# Traffic Impact Study (TIS) – Traffic Memorandum

## 16888 Elbert Road (Parcel 4122000002) – Special Uses

### Revision 5

Proposed Development and Trip Generation

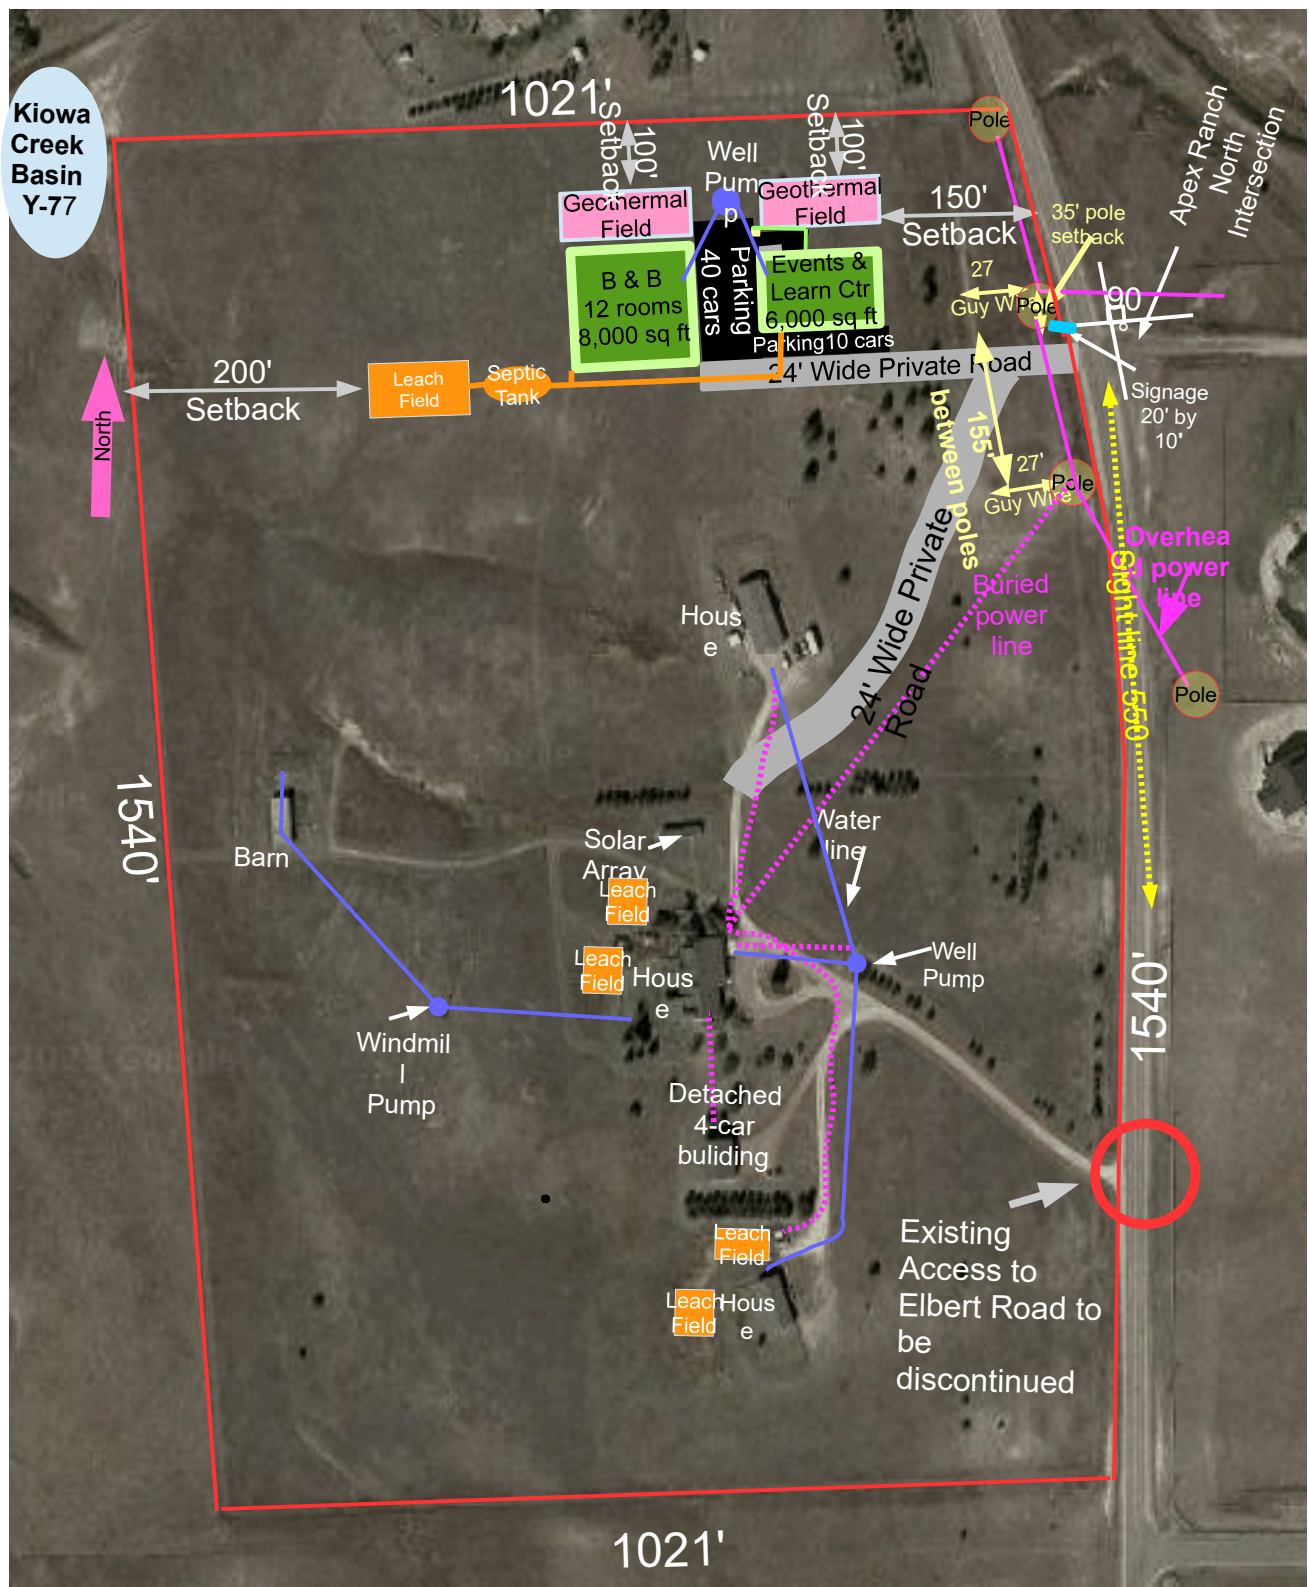
property is unplatted  
and a single parcel,  
no individual lots  
3 Single family homes

The onsite internal road is expected to be private. Private road is shown on site dev plan

Weekend Days Noon Average Hourly Traffic Flow for Intersections

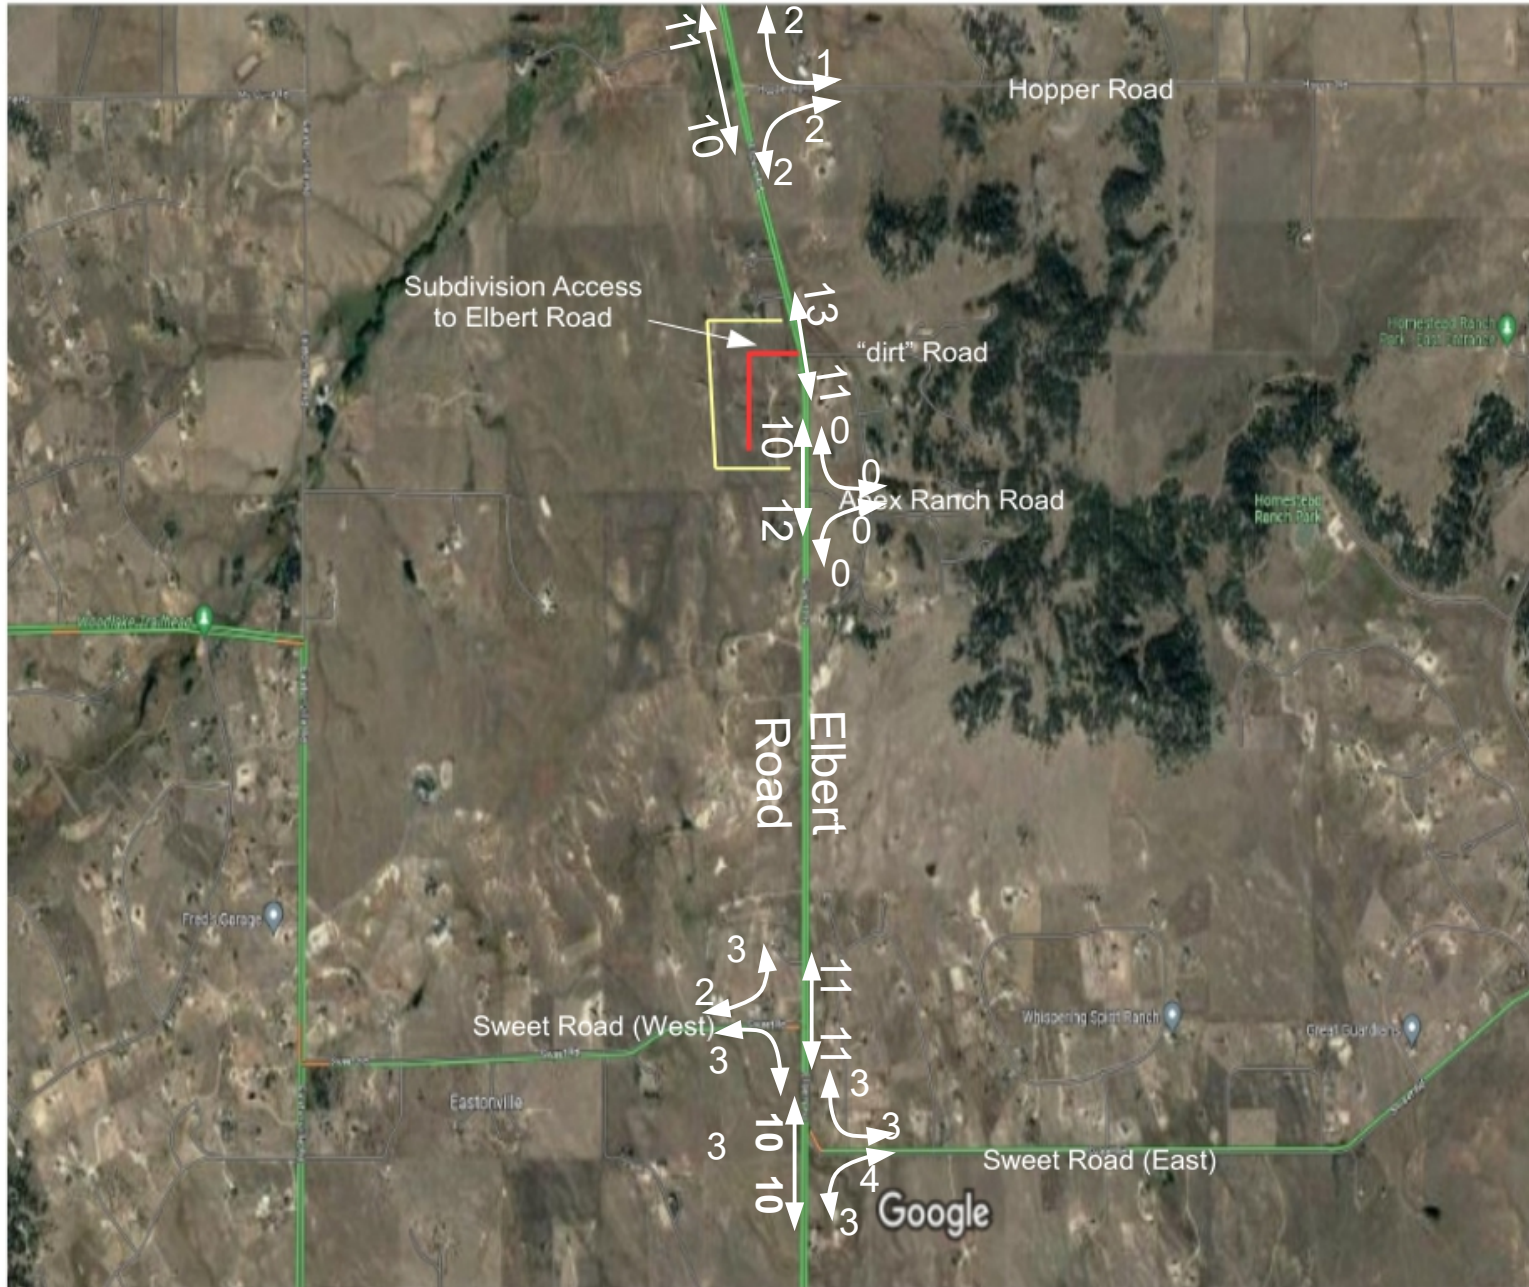
Label all maps as existing, short term and long term.

Add legend to all and update ADT and peak hr for all

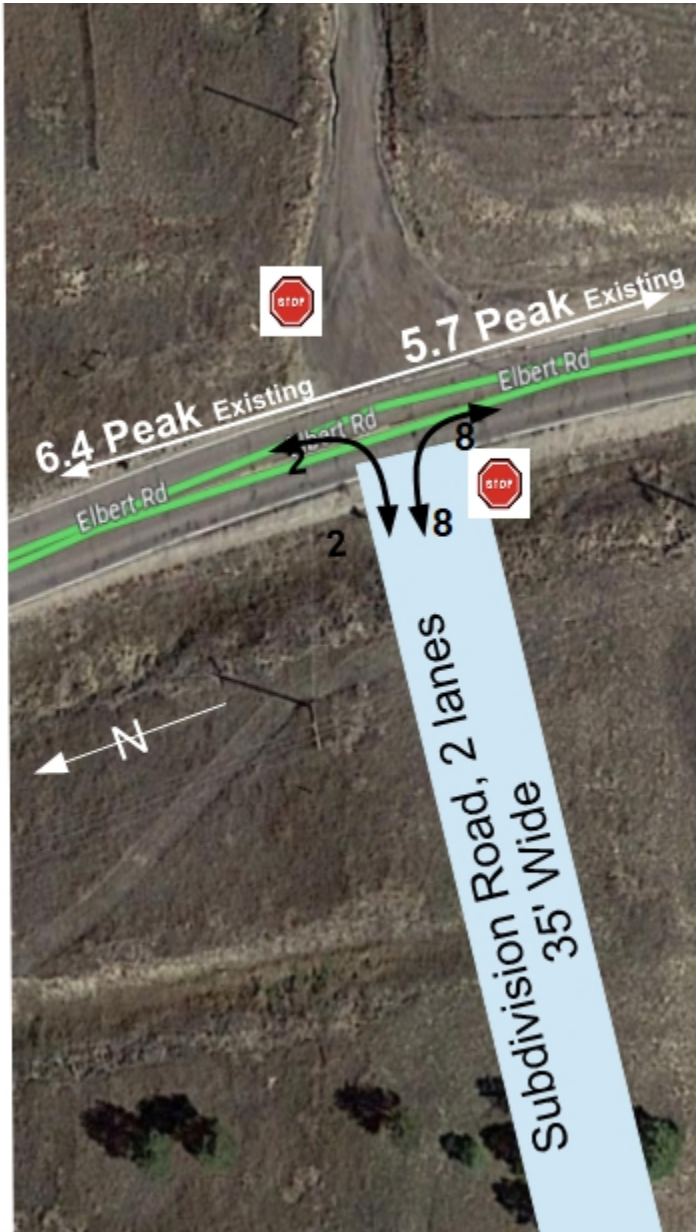
Include detailed Auxiliary Turn Lane Analysis per ECM 2.37.D Address both Northbound and Southbound with specific for a minor arterial and lower classification per 2.3.7.D. State the ECM standard, and if met or not based on trip gen
